From: Simon Davis
Sent: 04 February 2022 12:38
To: Sarah Sutcliffe
Cc: Chris Brake
Subject: RE: AL/141/21/RES Lees Yard

- Condition 5 of the outline requested that acoustic fencing be included in the RM submission. I note that this is referred to in the Compliance Statement (CS) but we need a specification of this. A separate layout plan showing all boundary treatments and then an accompanying specification/elevation for each type would be helpful.
We intend to provide this, just liaising with team to get this produced and over to you. I have responded separately.

Drawing Name Landscape Strategy

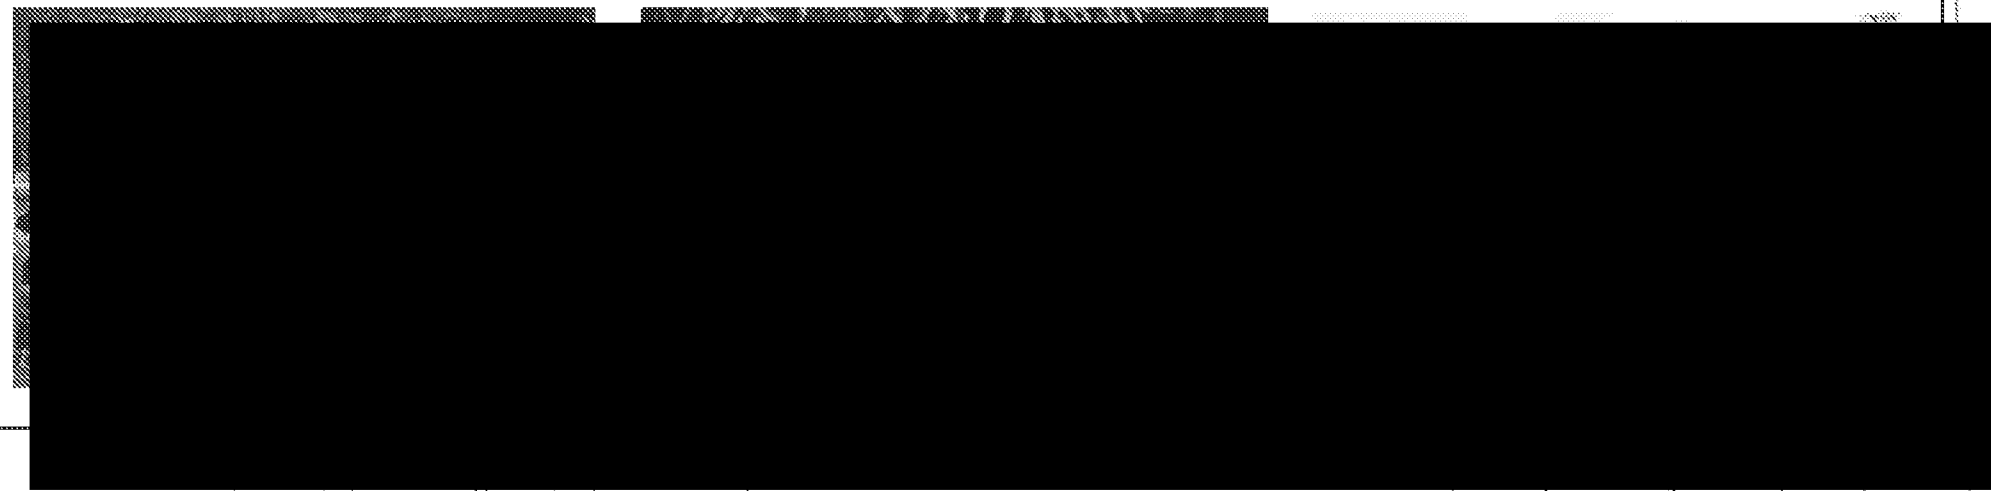
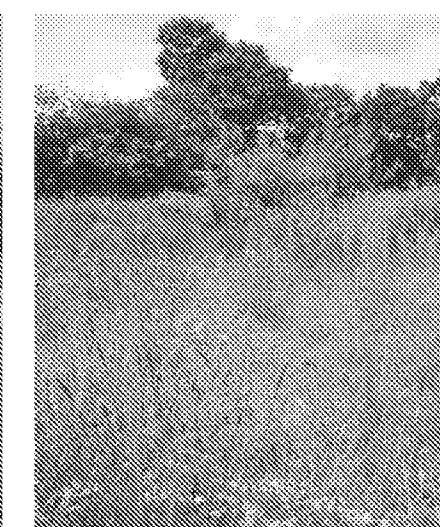
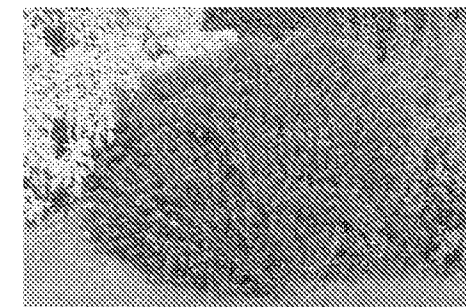
- We need full details of new landscaping as this is a reserved matter but we only have a strategy plan at present. I also have a concern that some of the street trees shown within the layout (particularly where adj to plots 15 & 19) don't have room to grow. We would suggest a suitably worded condition attached the RM permission would be more appropriate requiring submission and approval of detailed hard/soft landscaping details, a landscape strategy has been submitted to provide the framework for a future detailed design. Noted, we can of course impose a condition relating to landscaping. My concern remains re the trees between plots 15 & 19 as these are sandwiched between a boundary and road. In addition, I note that 23 trees are being removed across the site. We require replacement planting on a 2:1 basis to demonstrate biodiversity net gain in respect of trees. I have counted 41 trees from the Landscape Strategy Plan. Assuming my count is correct, can you show an extra 5 within the layout.

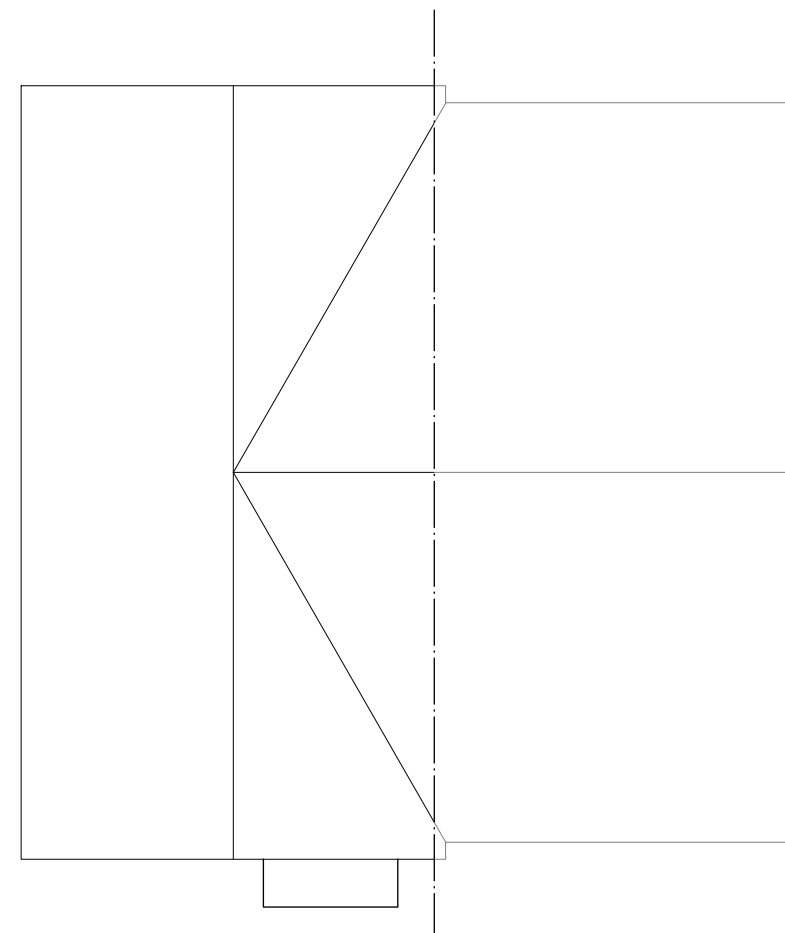
- I am having an issue scaling from the floor plans. They state 1:100 at A3 but I am getting measurements too low. For example, using this scale, double beds are only 1.4m long. We're not sure how this is happening, as both our internal design team and consultant architects have checked and both seem to be scaling correctly – if you continue to have an issue let us know and we can arrange for hard copies of plans to be provided if necessary. I have double checked here and have discussed with our Technical Support Manager. We think this has happened because you sent the house plans in a 'pack' and we first had to split this into individual pages before uploading. Can you send me a link to the plans that were in "PP-10364907_211216_21452_6001-6007 House Type Pack_Low Res" but provided as individual plans. I will then test one at my end and if that resolves it, we will replace all those on the website with the individual files.
